WEST SUSSEX COUNTY COUNCIL CONSULTATION

TO:	Arun District Council FAO: Simon Davis
FROM:	Stephen Gee WSCC - Highways Authority
DATE:	24 March 2020
LOCATION:	Land North of Lee's Yard, Lidsey Road, Woodgate, PO20 3SU
SUBJECT:	AL/21/20/OUT Outline application with some matters reserved for the erection of 38 No. dwellings consisting of 5 No. 4-bed house, 14 No. 3-bed houses & 19 No. 2-bed houses, with communal work hub & associated car parking & landscaping (resubmission following AL/57/18/OUT)
DATE OF SITE VISIT:	
RECOMMENDATION:	No Objection
S106 CONTRIBUTION TOTAL:	n/a

Land At Lidsey Road
Proposed Site Plan [DRAFT FOR COMMENT]

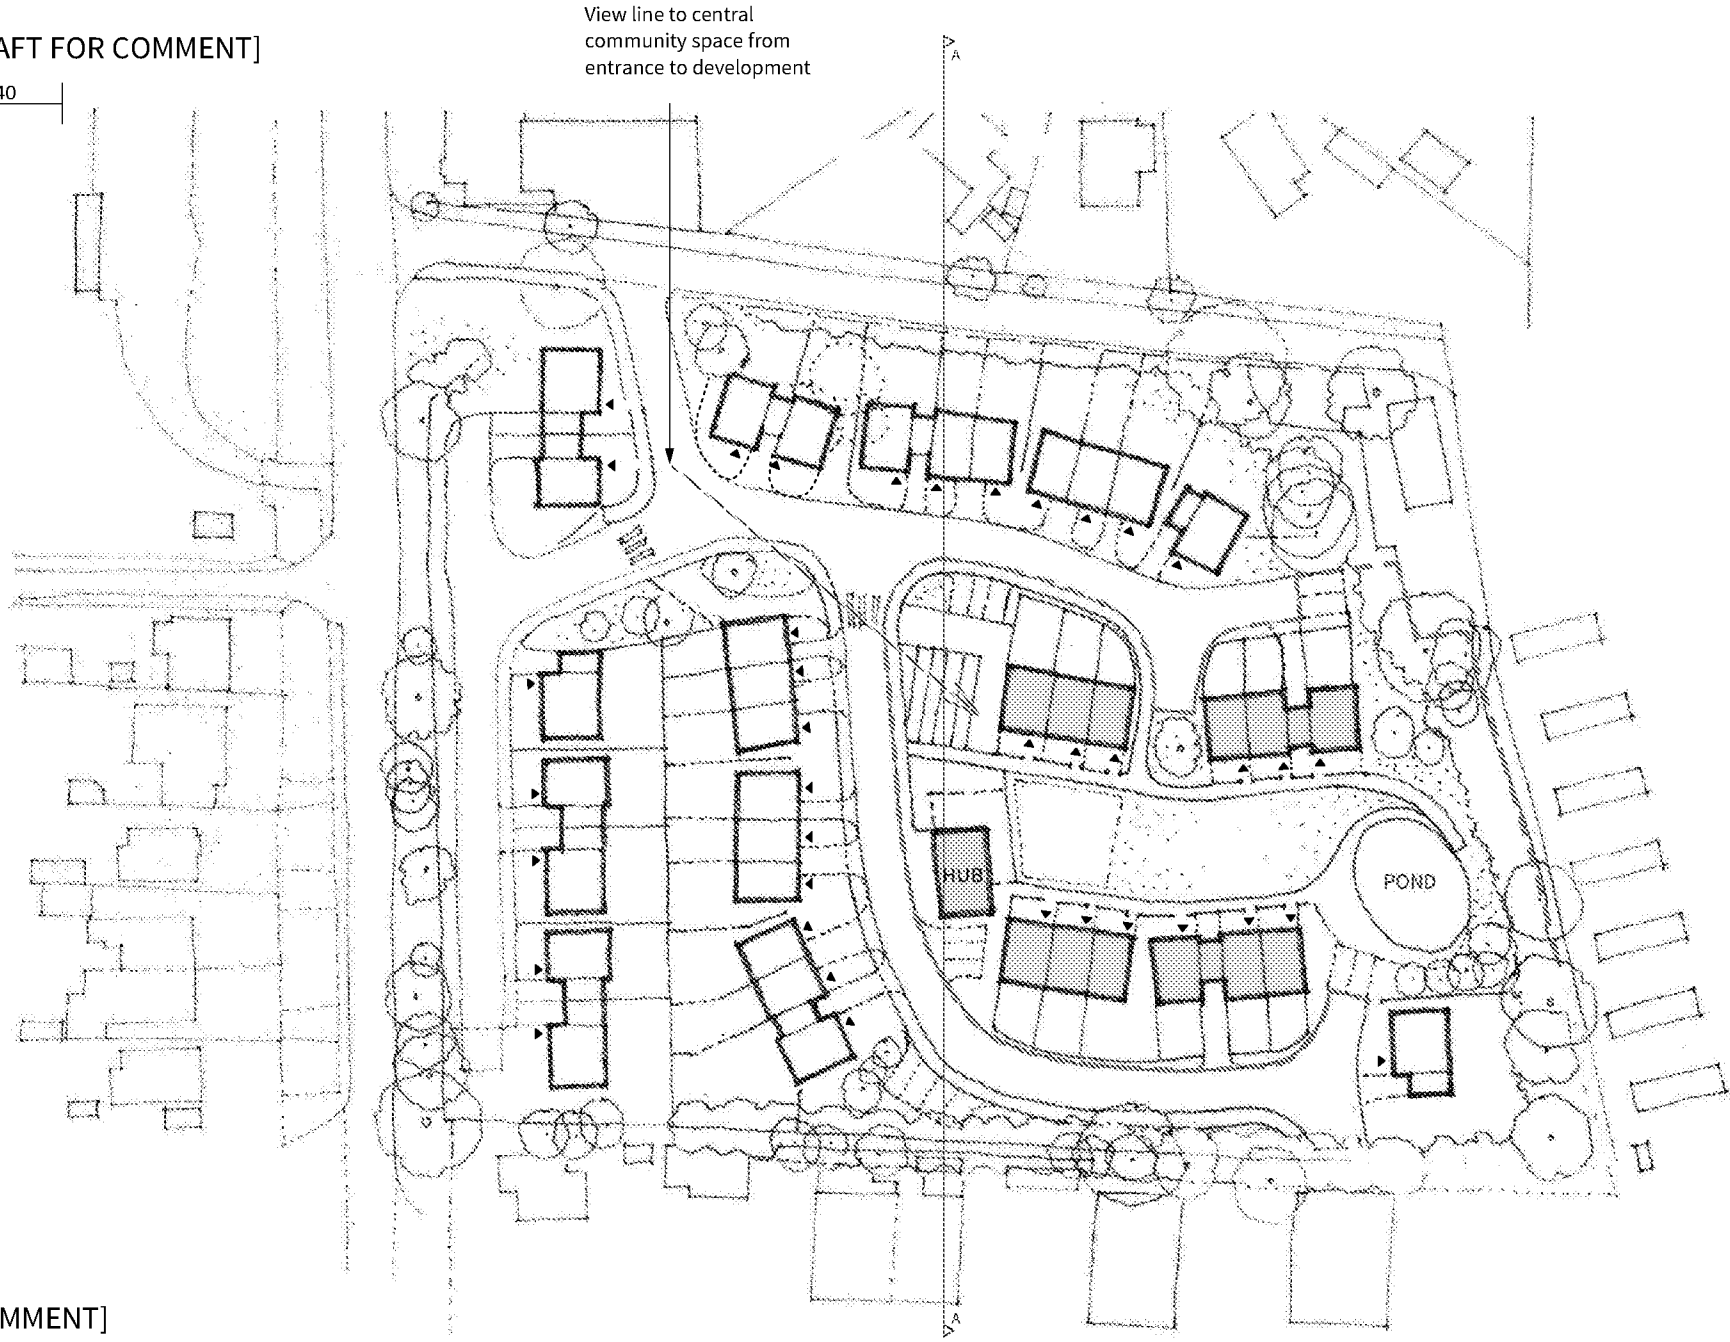
Whilst a reserved matter the application form states a total of 43 spaces would be provided. This is significantly under the standards provided within the Arun Parking Standards however there would appear to be sufficient space within the site to accommodate an increased level in accordance with standards.

Whilst layout is a reserved matter, vehicle tracking for a refuse vehicle has been provided and is accepted. Bin stores/carry distance would also be required at RM stage.

No dwelling shall be first occupied until the car parking serving the respective dwelling has been constructed in accordance with plans and details to be submitted to and approved in writing by the Local Planning Authority. Once provided the spaces shall thereafter be retained at all times for their designated purpose.
